From: Amanda Scholes on behalf of Planning.Responses
Sent: 17 March 2021 11:56
To: Planning Scanning
Subject: FW: FG/19/21/PL - First Floor Flat, 60 Ferring Street
Attachments: BD 20148 PLANS-02-01.pdf

TITLE	PROPOSED FIRST FLOOR PLAN & PARTY WALL TREATMENT DETAIL
-------	--

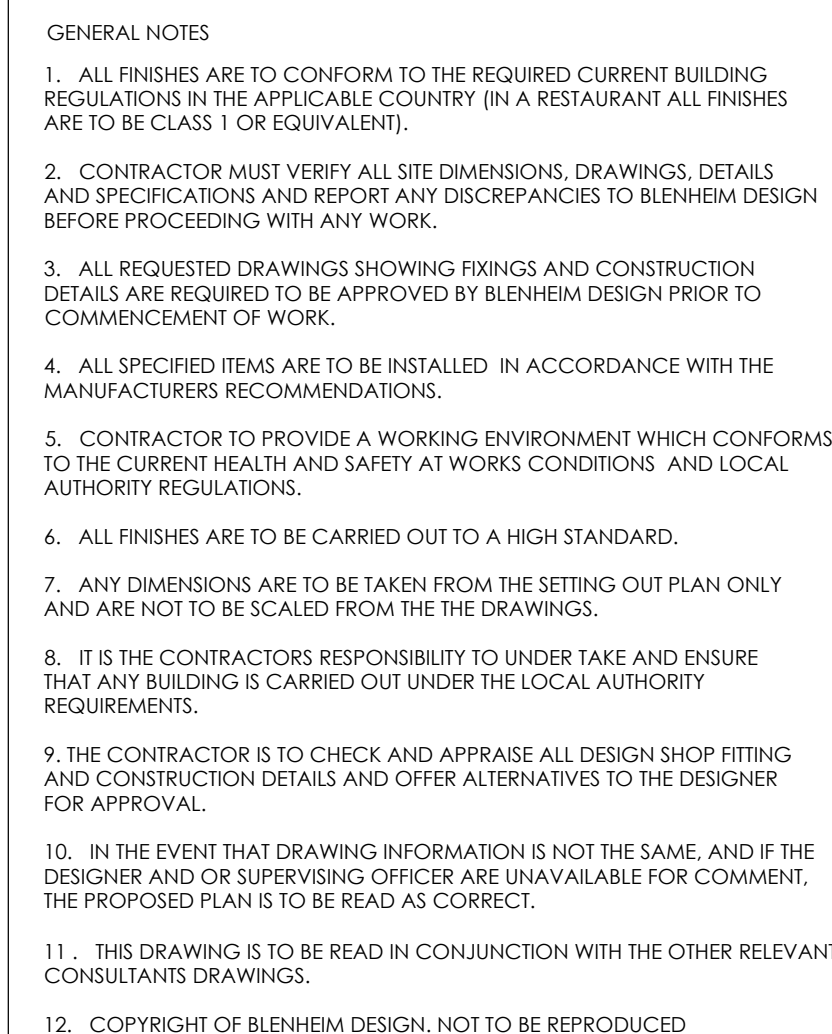
Can you provide some details of the sound attenuation /protection measures you are intending to install to support this application

Please find attached drawing showing proposed sound insulation.
